Demolition & erection of 1 No. dwelling with swimming pool.
Little Deerswood Gorse Avenue East Preston

Thank you for your internet representation made on 27th August 2018 which has been recorded as '**an objection**' with the comments as follows:

I am commenting on this application on behalf of the East Preston and Kingston Preservation Society.

North & East Elevations as proposed

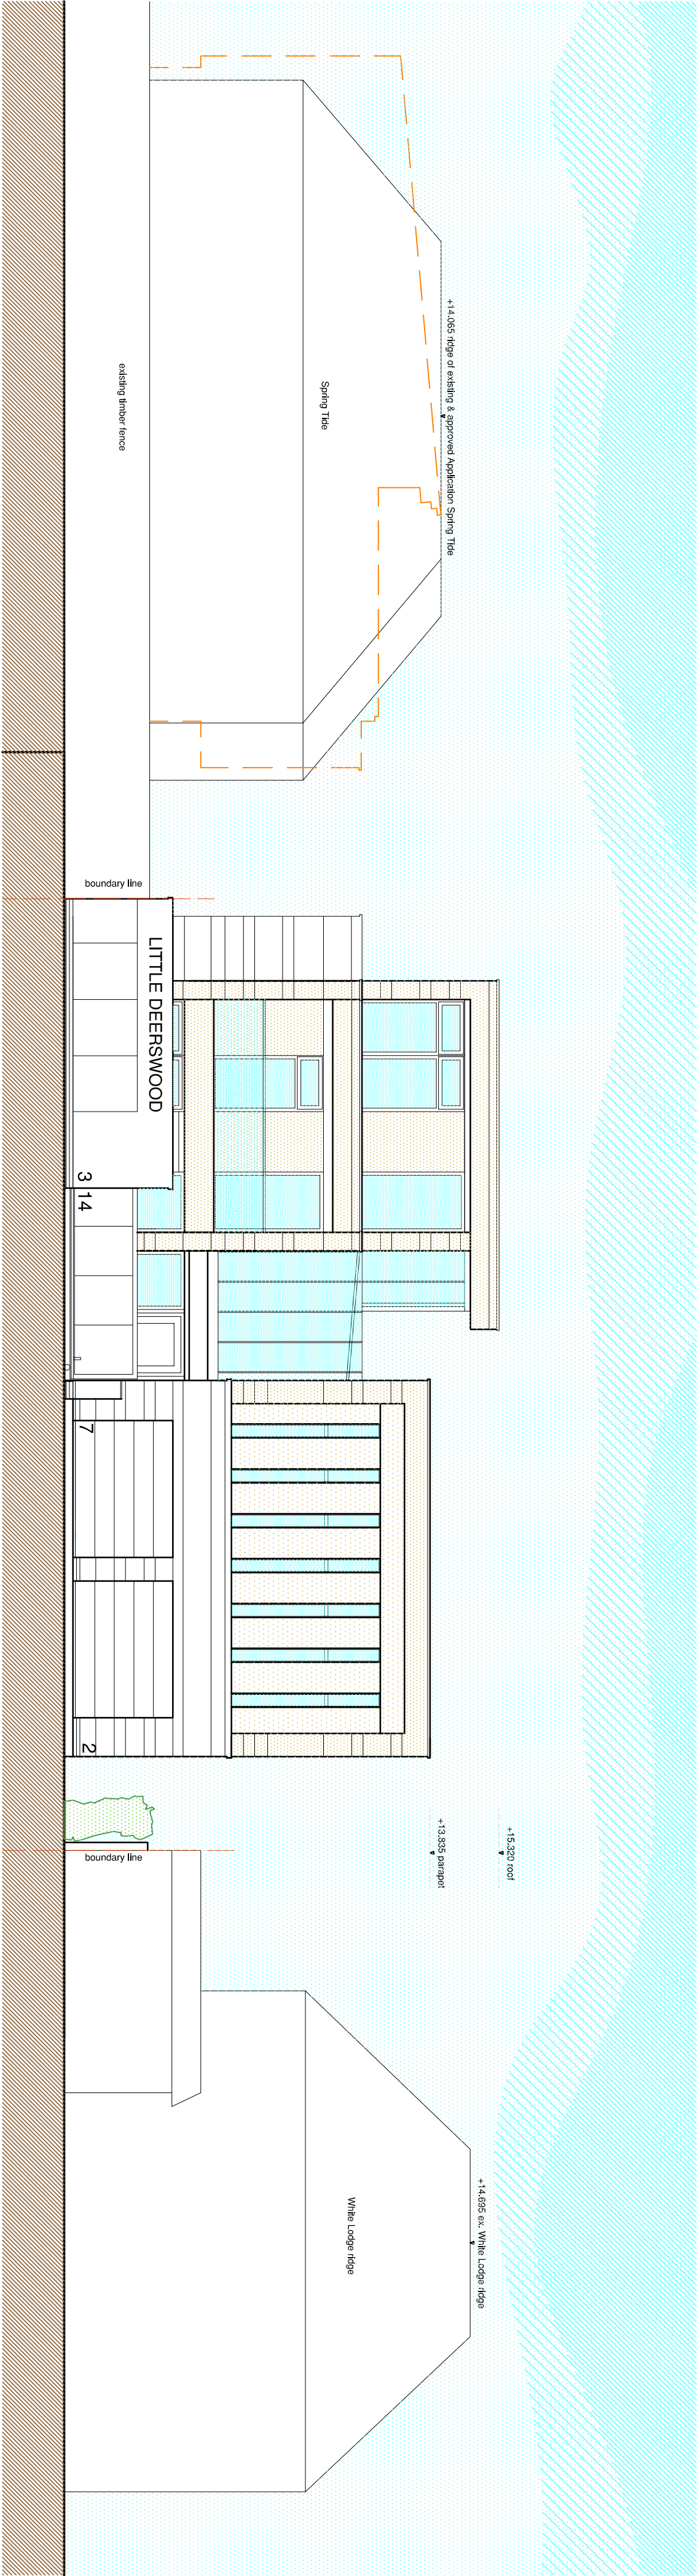
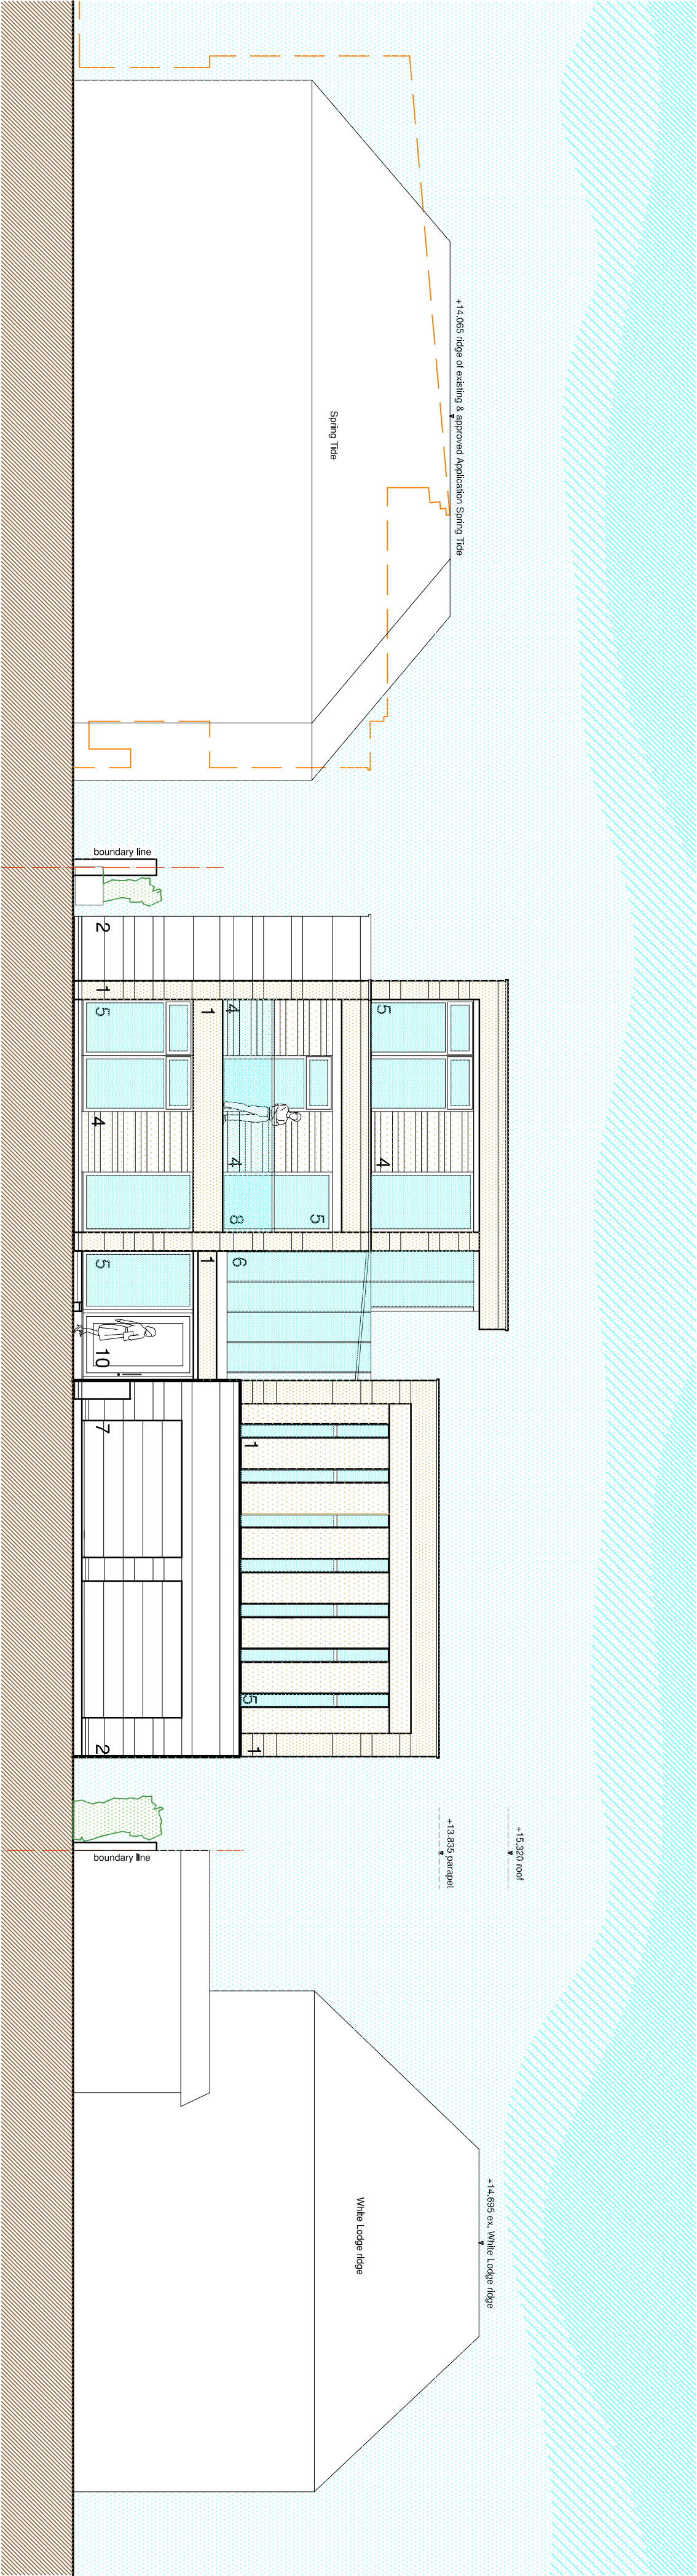
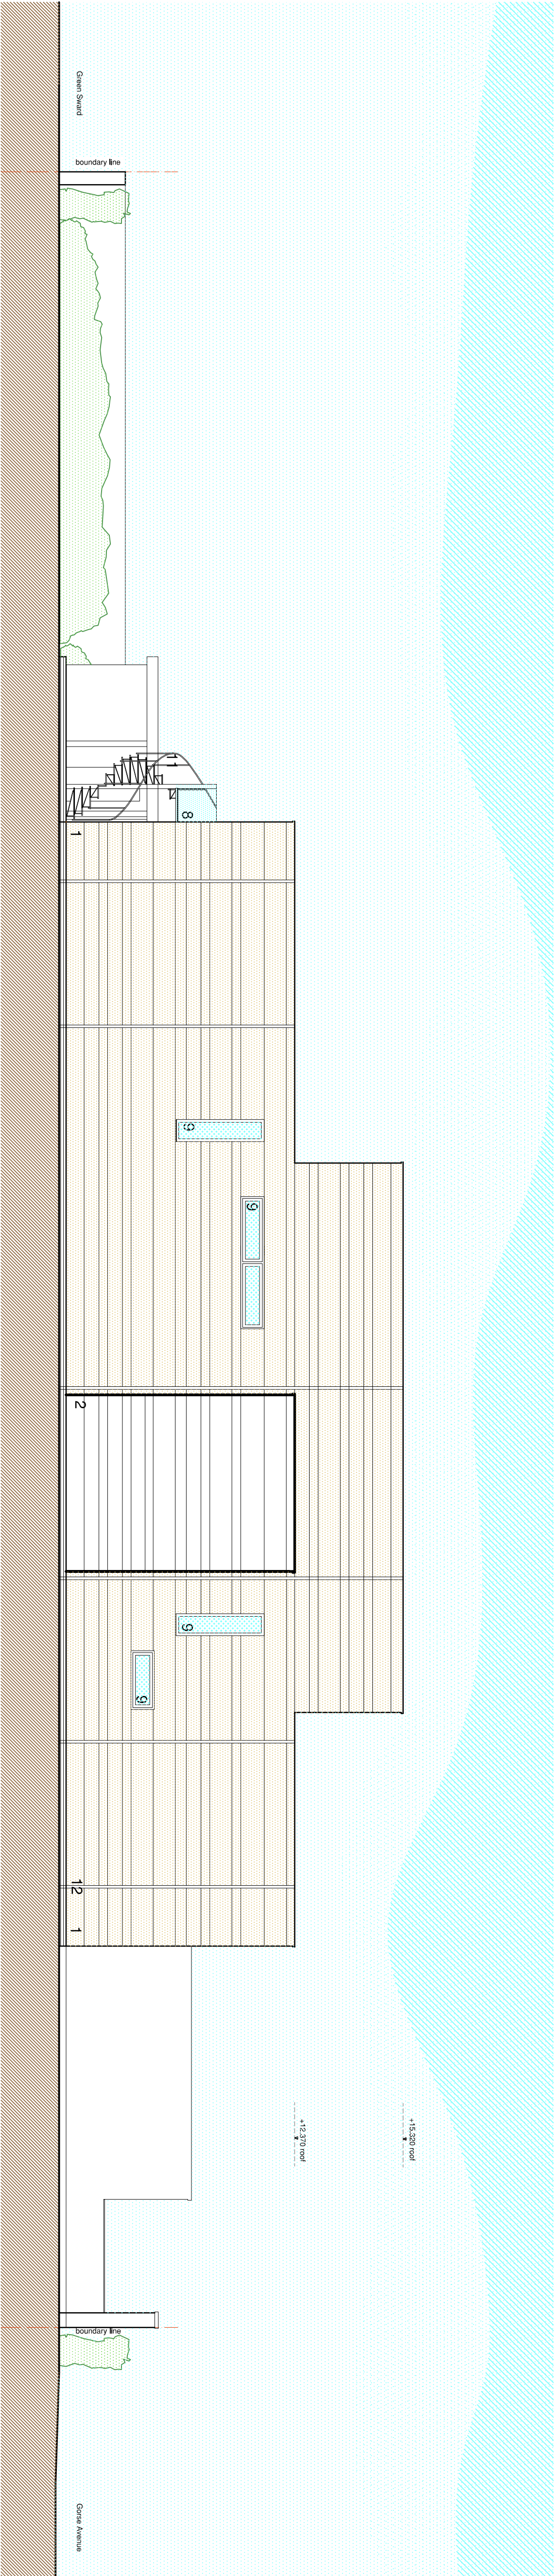
The design of the house bears no relation to that of its neighbours. It is extremely urban in character and some aspects can only be described as ugly - notably the eastern facade and the grill on the northern facade.

Site Plan as proposed

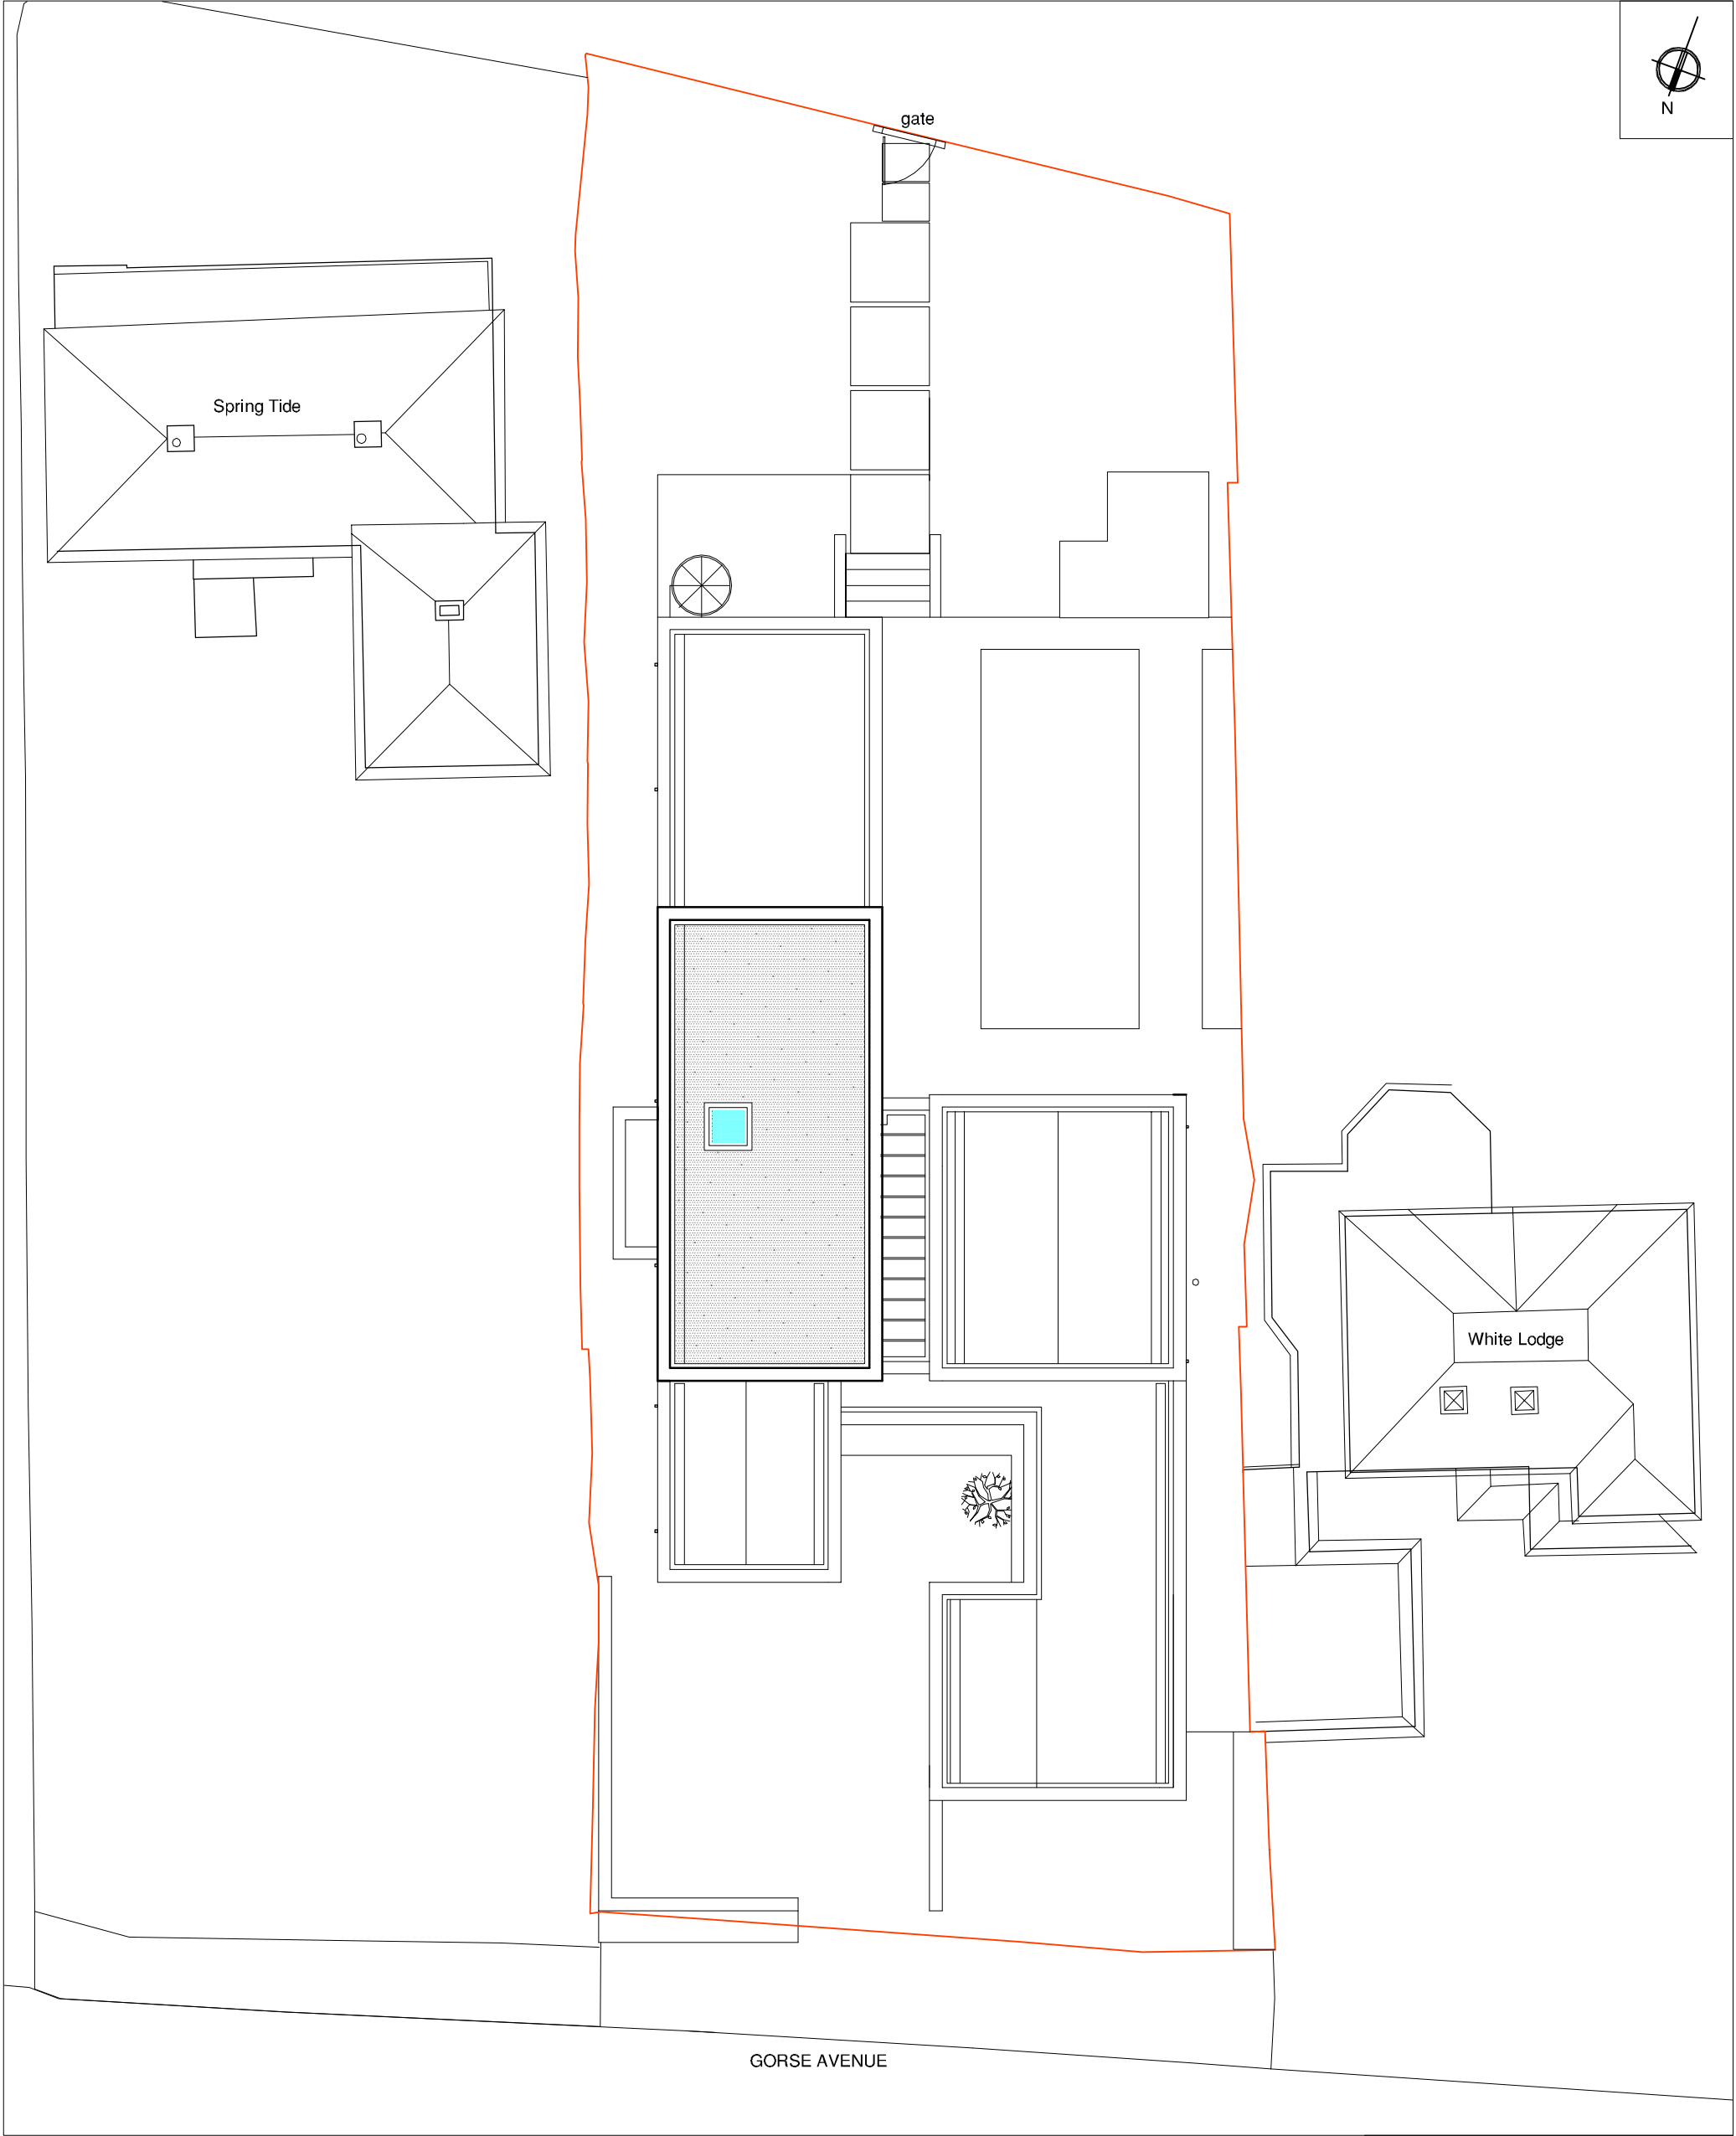
This application represents an insensitive attempt to insert a large house into a narrow site. As a flat roofed three storey building, it is taller than its neighbouring two storey houses with pitched roofs. It would extend significantly south of the building line on the beach side of the site, and appears to have a number of windows in its western facade (which, significantly, is not shown specifically among the published plans) that would overlook the south facing windows and gardens of its western neighbours.
